From: [David O'Connell](#)
To: [Michelle Niles](#)
Subject: RE: Notice of Modification Request - Casuarina Town Centre Project Approval (MP 06_0258 MOD 12)
Date: Wednesday, 20 February 2019 4:12:37 PM
Attachments: [image001.png](#)
[image002.png](#)
[image003.jpg](#)
[image004.jpg](#)
[image005.png](#)
[image006.jpg](#)
[image007.jpg](#)
[image008.png](#)
[image009.jpg](#)
[Selection from Working copy - CC18_0924 - Civil Plans - Casuarina Way Ca....pdf](#)

Subject: Notice of Modification Request - Casuarina Town Centre Project Approval (MP 06_0258 MOD 12)

The proposal seeks approval to subdivide SP 94481 into two separate allotments, to correct an error in the Survey undertaken during works associated with MOD 6 which incorrectly amalgamated a car parking lot and medium density housing lot.

14/09/2018 3:32:39 PM P:\BGE\BNE\B16097\100 DRAWINGS\102 CIVIL\AUTOCAD\B16097-DRG-C-0005.DWG

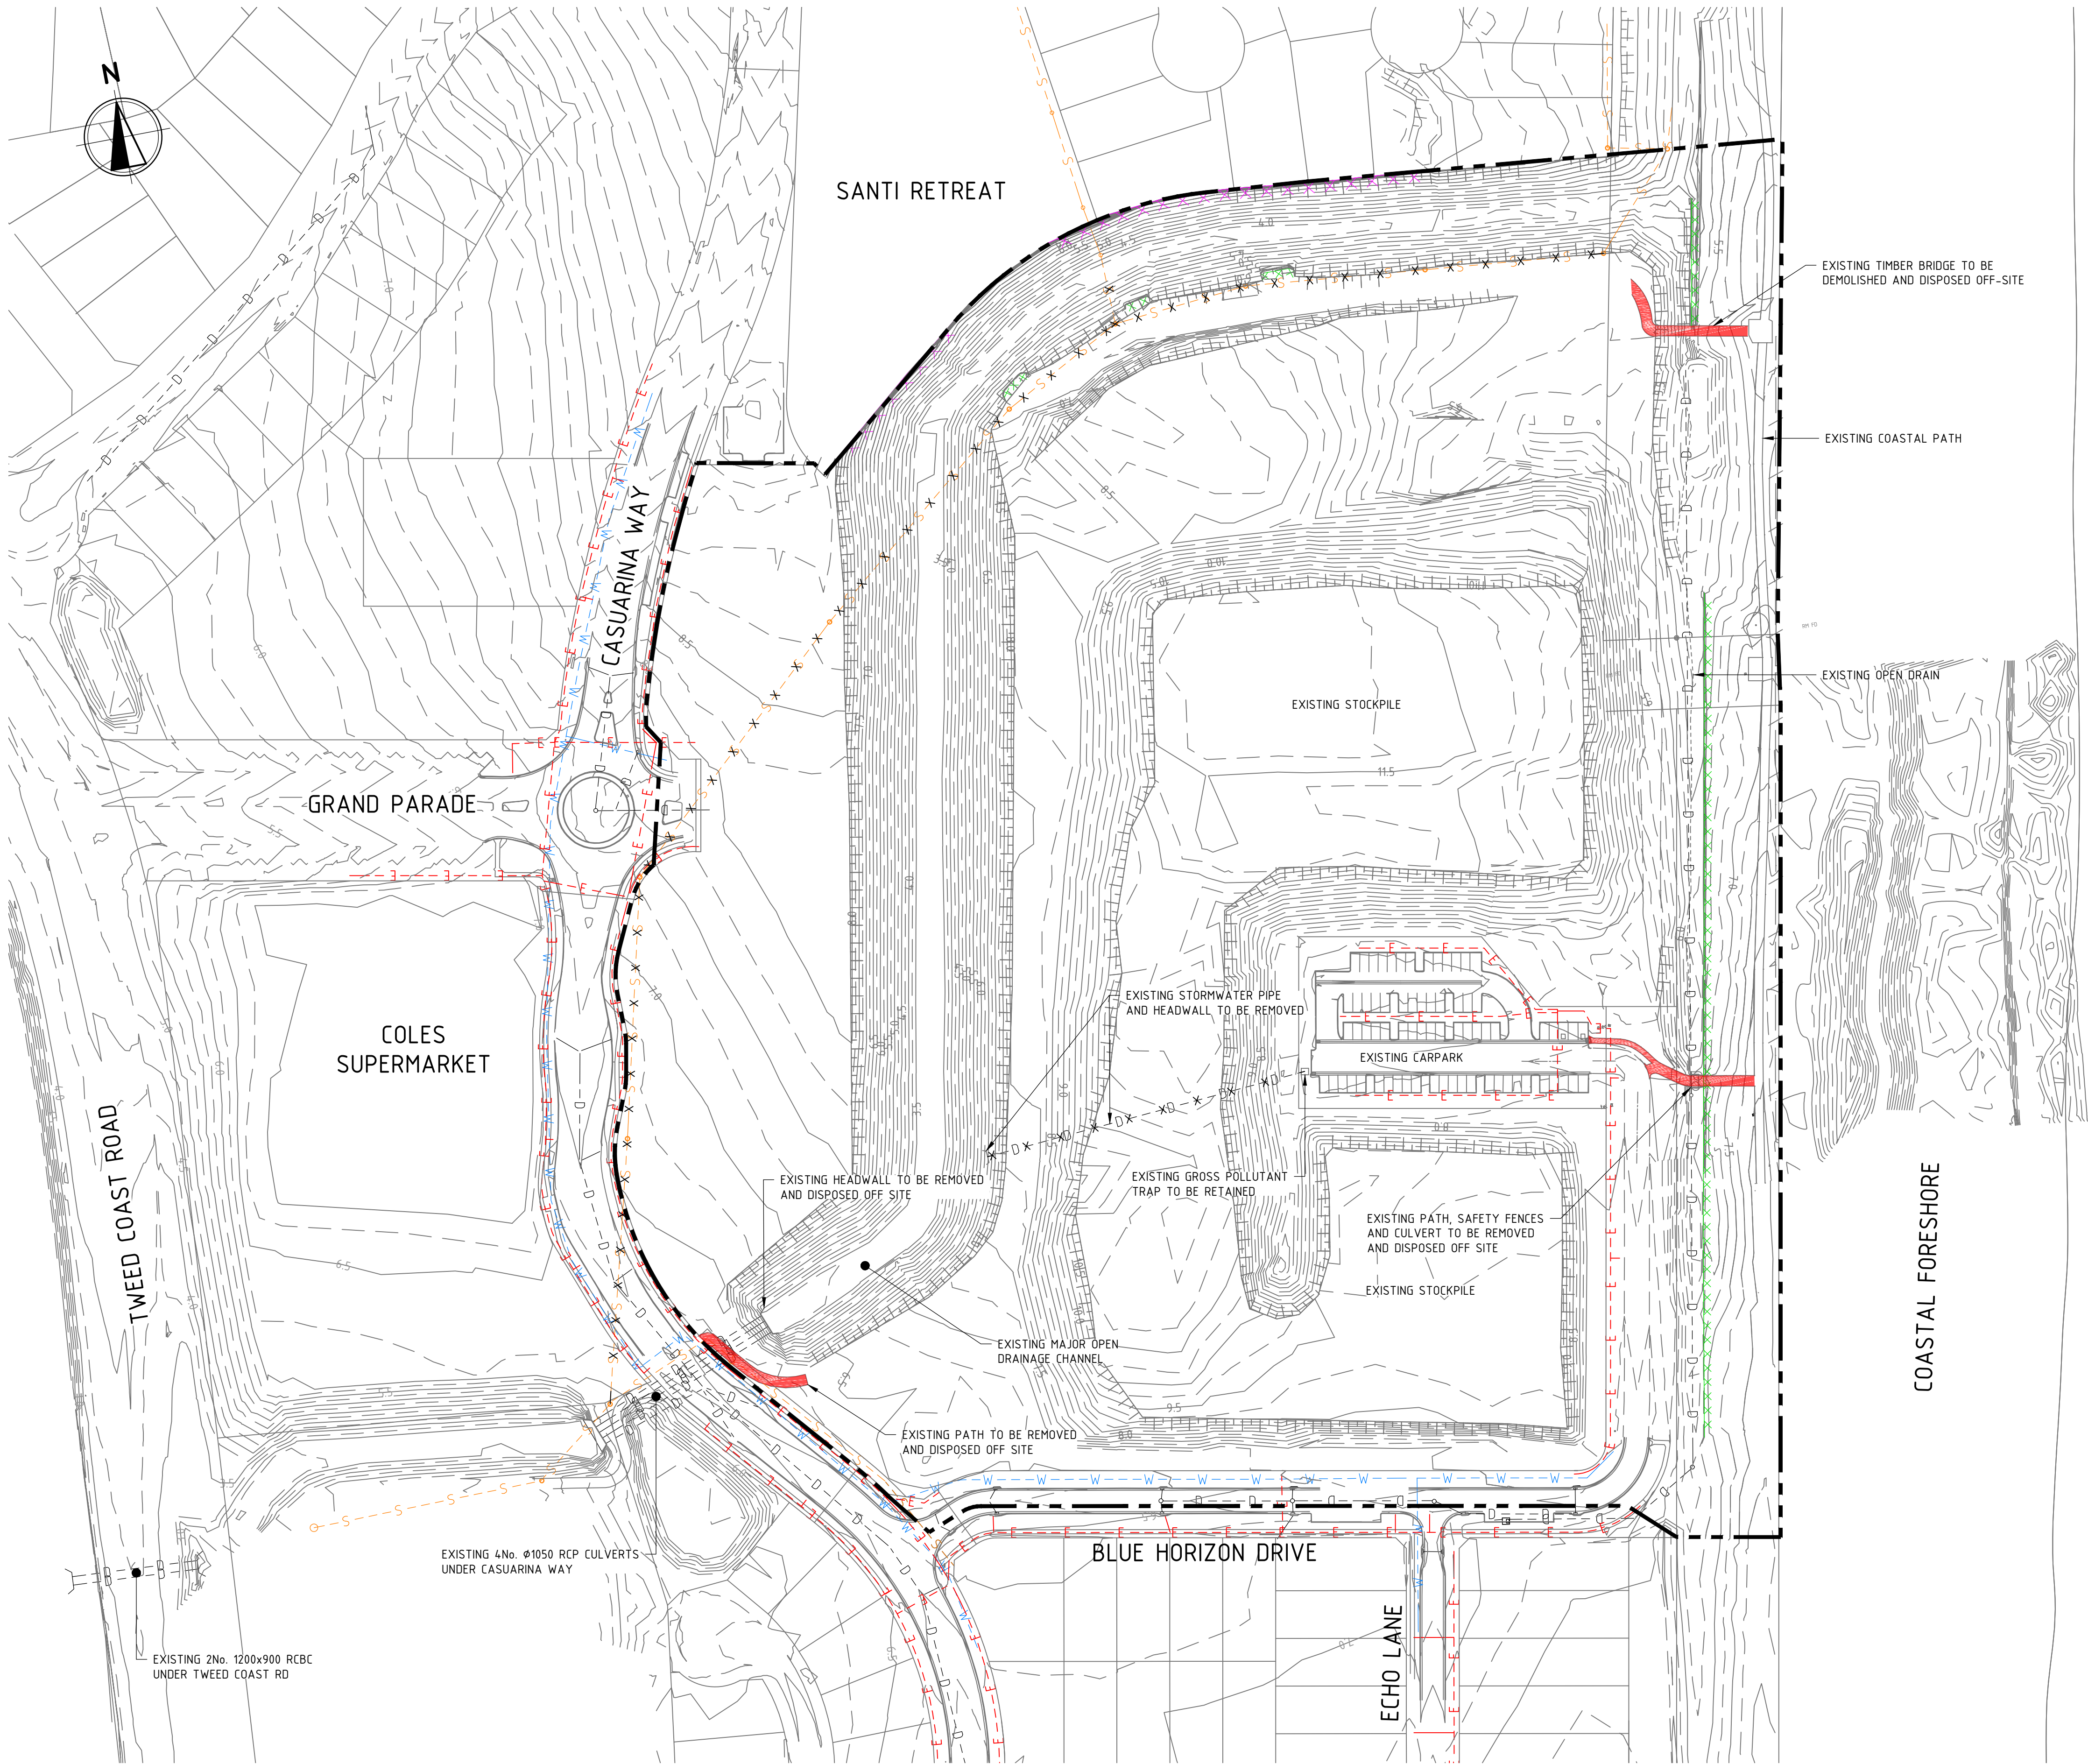
'It seems like they are proposing to connect into a trunk sewer line that is proposed to be removed / abandoned (see attached plan).
